**External Envelope:
Glass & Aluminium and
Stone Façade Elements**

CADENZA METROLINK INTERFACE

Cadenza, Earlsfort Terrace, Dublin

**Document No:
1087-BDA-XX-ZZ-RP-Y-0001-C02**

Figure 5 EWS 002 Stone Veil typical bay, elevation and section

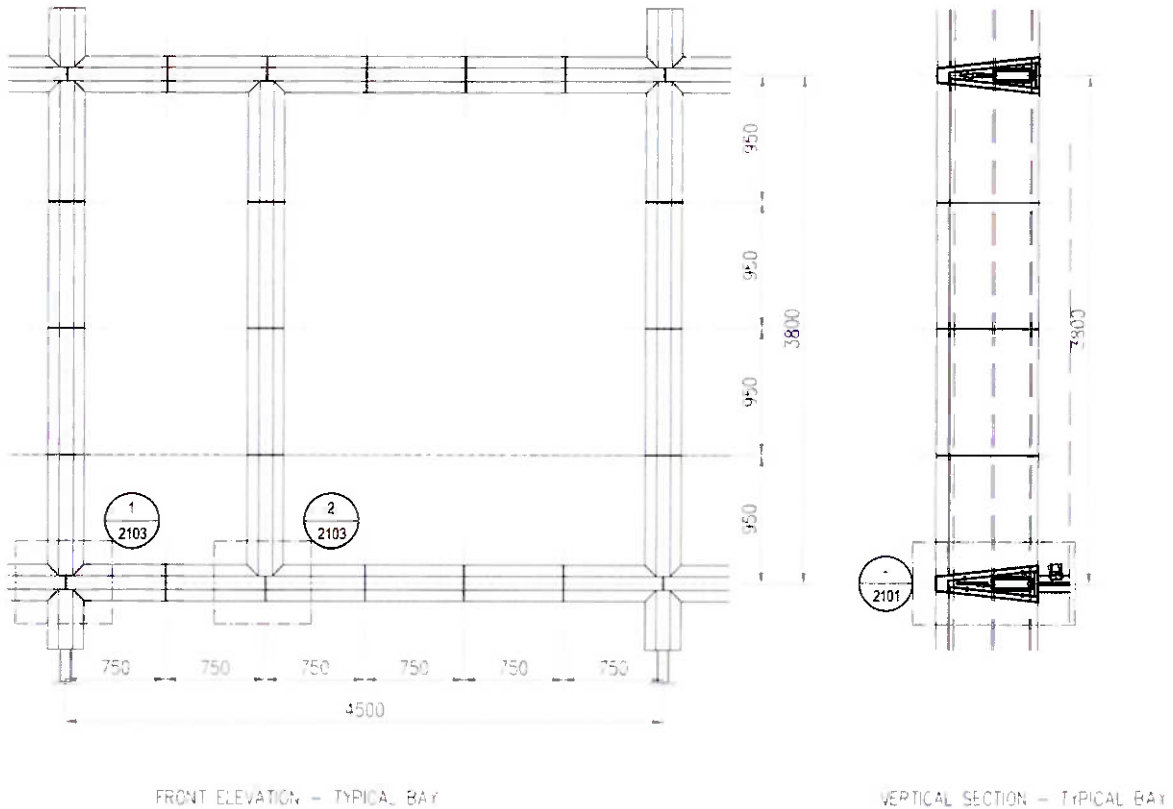
Deflection of the Level 5 slab directly effects the shape of the veil on elevation as it is all suspended from this slab. Vertical deformation of the veil from the rectilinear grid installed on-site is accommodated by the flexing of horizontal members and silicone pointing between stone pieces.

Differential movement (racking) of the primary structural floors causes the veil suspension structure to deform out of square. Flexing at horizontal to vertical frame joints is restricted by flexing of the interlocking bracketry and the silicone pointing in stone to stone joints.

Figure 13 EWS-001 Plan view, glass-to-glass corner condition adjacent to Gridline D, South elevation.

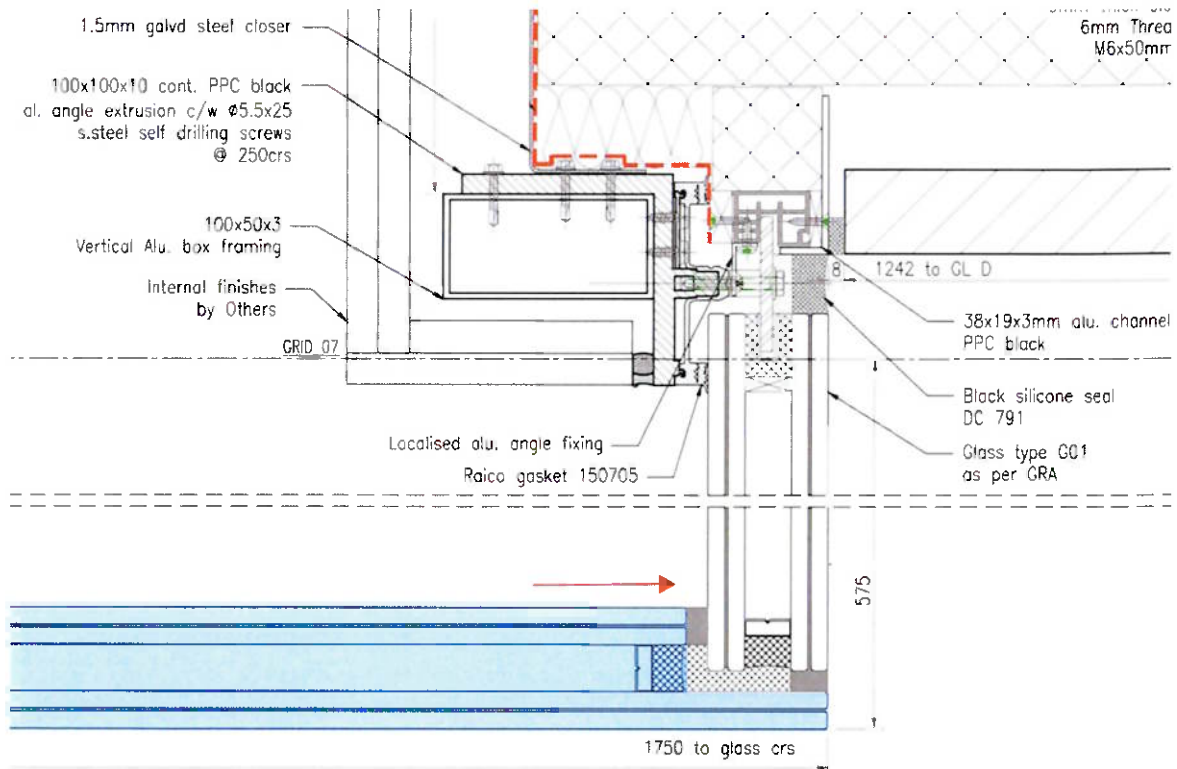
Due to the aspect ratio of the panels closest to gridline D on the South elevation, the TII predicted differential settlement of 19.5mm from Gridline C to D would result in 1.75m wide panels rotating in plane not less than 2.8mm at their base. As each panel is 3.5m tall this translates into 5.3mm rotation at the top corner of the panel. Such rotation would exceed the design parameters of the structural sealant at the glass to glass joint crushing and tearing the sealant and inducing stress in the glass. It may not cause breakage but will apply long-term stress into the structural sealant joint which may cause failure of the structural connection.

Figure 13 EWS-001 Plan view, glass-to-glass corner condition adjacent to Gridline D, South elevation.

Figure 16 EWS-002 Vertical section of stone profiles with support structure (typical horizontal fin)

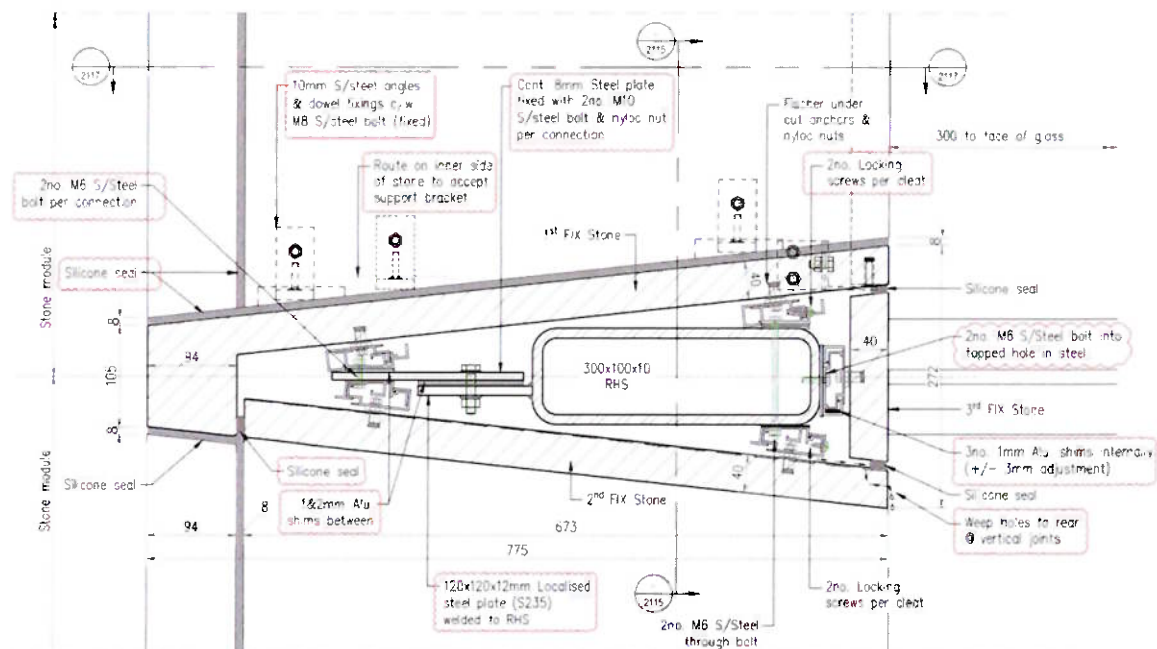
As can be seen from the diagrams above, the structure supporting the veil is entirely bespoke. Stone, being a fragile material, is extremely limited in its capacity to accommodate movement.

Figure 19 EWS-003 South elevation, Deformation due to ground settlement

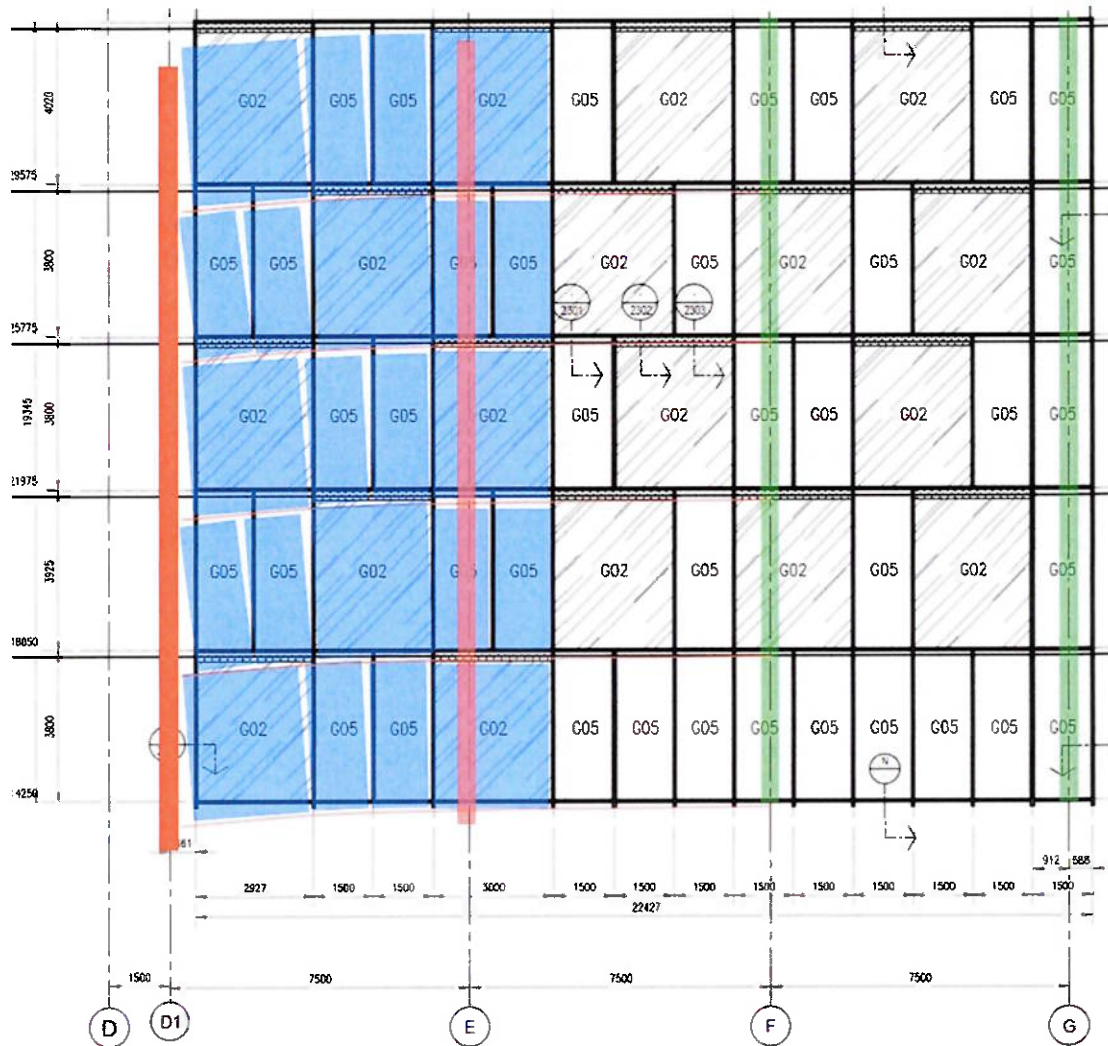
According to the TII's document EIAR Appendix 5.17 Building Damage Report page 126 of 158 and 'Addendum to the EIAR – Downward Tunnel Realignment: St Stephen's Green Station to Charlemont Station (P01 06.03.2024)' the South elevation of EWS-003 will suffer differential settlement of approximately 19.5mm from one side of the screen to the other in the final condition. A similar differential deflection will occur along the Eastern EWS-003 façade during the tunnelling operation as the building's structure deforms.

The curtain wall system has very little capacity for racking of the glass on elevation. When the structure moves differentially as per the diagram above, the mullions remain vertical and the transoms rotate in plane. As each glass unit sits on a transom, the glass rotates with the transom. Based on the TII EIAR addendum there is approximately 19.5mm of differential settlement across quite a small width of approximately 10m.

Figure 20 EWS-003 Plan section of glass to mullion interface.

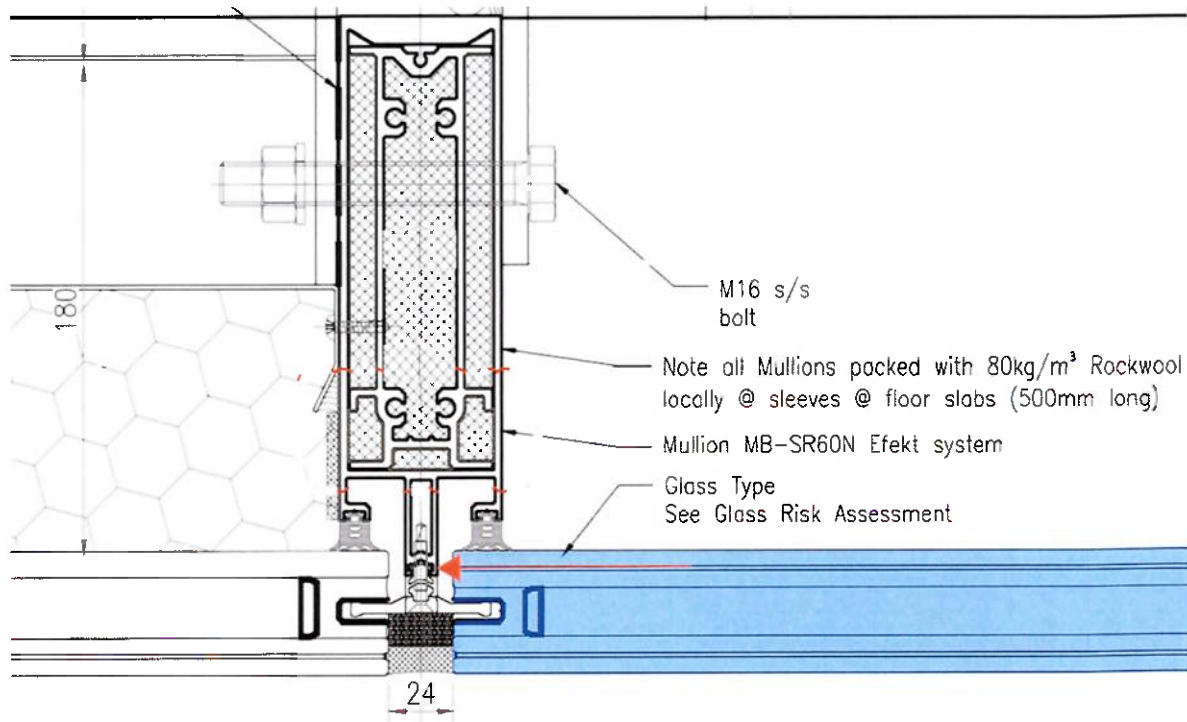
Due to the aspect ratio of the panels closest to gridline D1 on the South elevation, and along the Eastern elevation, the TII predicted differential settlement of 19.5mm in this area would result in 1.5m wide panels rotating in plane not less than 2.9mm at their base. As each panel is 3.8m tall this translates into 7mm rotation at the top corner of the panel. The toggle glazed system does not have capacity for this degree of movement. The mullion detail below shows the proximity of glass to metal. If the glass rotates too far, the inner glass impacts the aluminium mullion profile causing breakage. The design gap, including glass tolerances and installation tolerances would be estimated as between 2mm and 6mm.

Figure 21 EWS-006 General arrangement and panel dimensions (South is to the right of this image).

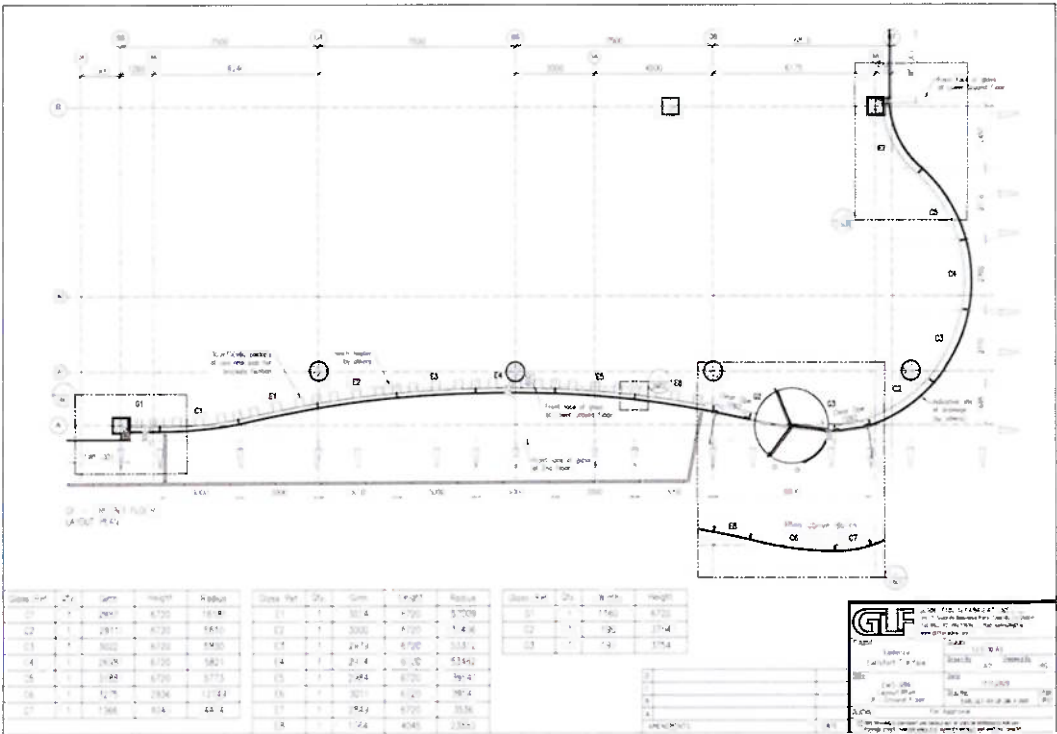
The entrance glazing is the most challenging façade system on the project and the most likely to suffer damage should there be differential settlement of the primary structure. As illustrated in Figure 10, if the TII works are positioned as intended, the entrance glazing should not suffer differential settlement. However, If the tunnel were to be positioned up to 15m to the West, which is still within the maximum proposed horizontal LoD, the worst case differential settlement would be applied to this screen across the South elevation where the glass is tightly curved and least able to accommodate racking on elevation.

The curved panels of glass are approximately 6.7m tall. The widest panel is 3.188m wide. To put this into context, 6m x 3.2m is the largest standard size of glass available. In order to get glass 6.7m tall, the float-line where the glass is changed from molten material to solid sheet, requires a special instruction to cut over-sized pieces. These then require specialist transport to the glass processor's facility as standard glass transporting trucks (called 'floatliners') are set up for carrying 6m lengths. Due to their size, the glass processor requires specialist equipment to convert the individual sheets of glass into laminated curved glass and then assemble into curved double glazed units. Due to the geometry of the building, each double-glazed unit in EWS-006 is unique.
